Subject: Rezoning Petition Review

Rezoning Petition #: 22-130

Location of Property: Approximately 1.04 acres located at the northwest intersection of Carmel Rd and Little Ave, north of Pineville-Matthews Rd and east of Johnston Rd.

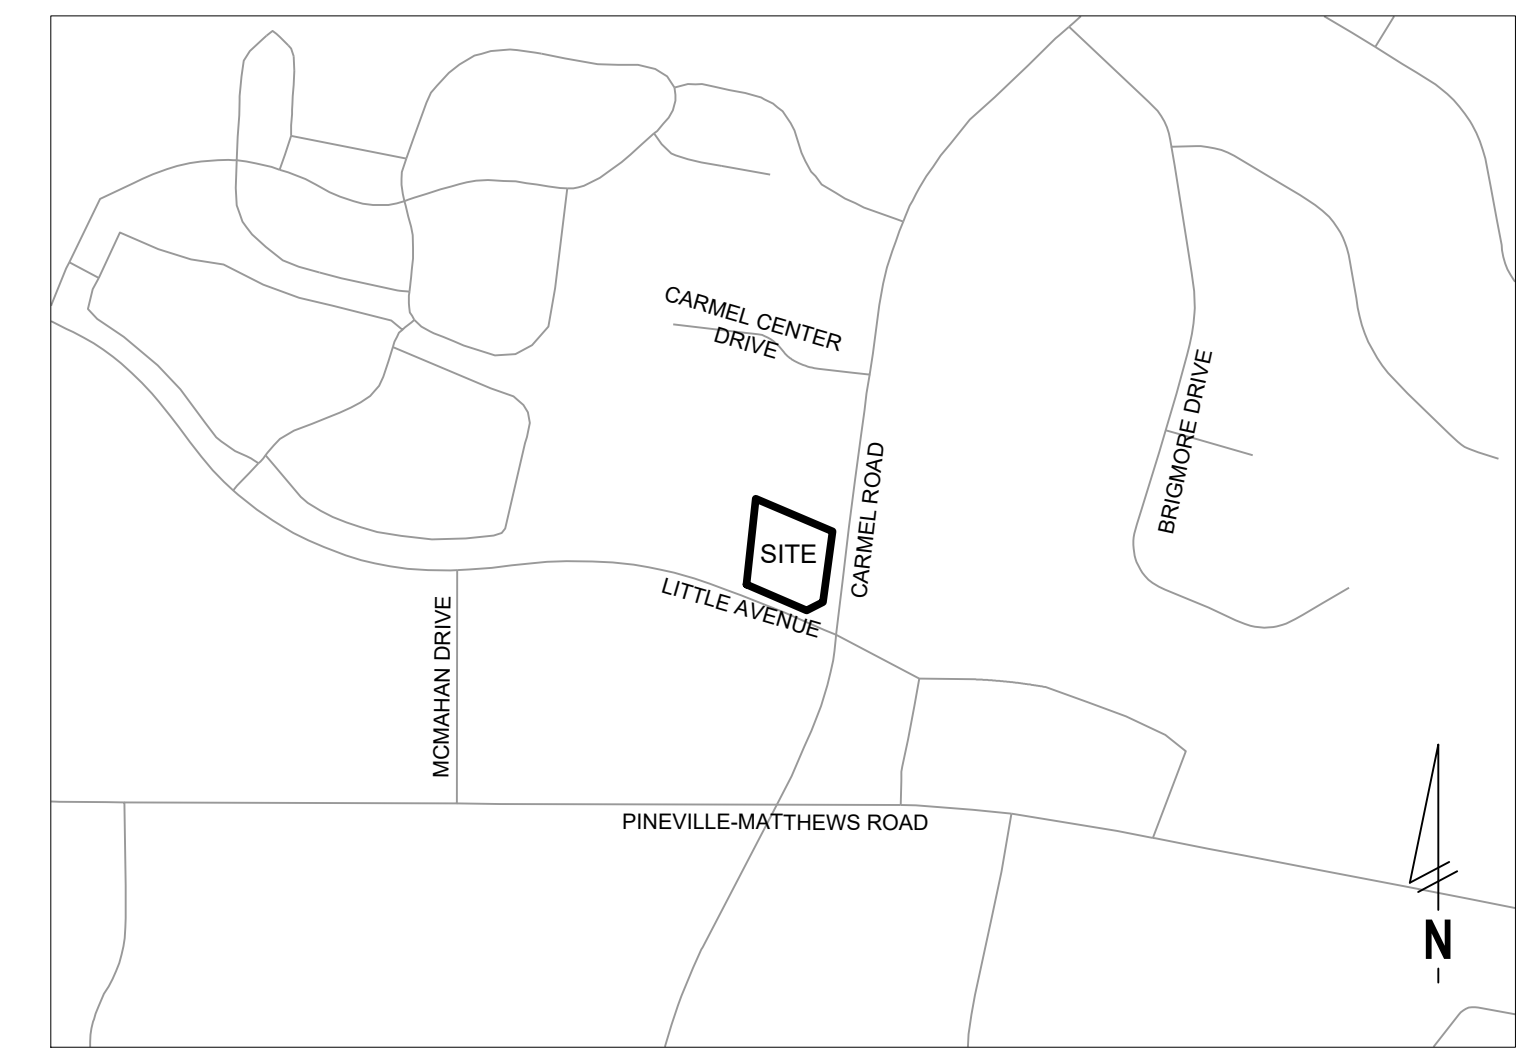
This property drains to McMullen Creek, which is an impaired/degraded stream, and may contribute to downstream flooding. This project has the opportunity to mitigate future impacts to this stream, therefore, Storm Water recommends placing the following notes on the plan:

For defined watersheds greater than 24% built-upon area (BUA), construct water quality stormwater control measures (SCMs) designed for the runoff generated from the first 1-inch of rainfall for all new and redeveloped BUA associated with the project. SCMs must be designed and constructed in accordance with the Charlotte-Mecklenburg BMP Design Manual.

For defined watersheds greater than 24% built-upon area, control the entire volume for the 1-year, 24-hour storm for all new and redeveloped BUA associated with the project. Runoff volume drawdown time shall be in accordance with the Charlotte-Mecklenburg BMP Design Manual.

For commercial projects with greater than 24% BUA, control the peak to not exceed the predevelopment runoff rates for the 10-yr, 6-hr storm and perform a downstream flood analysis to determine whether additional peak control is needed and if so, for what level of storm frequency, or if a downstream analysis is not performed, control the peak for the 10-yr and 25-yr, 6-hour storms.
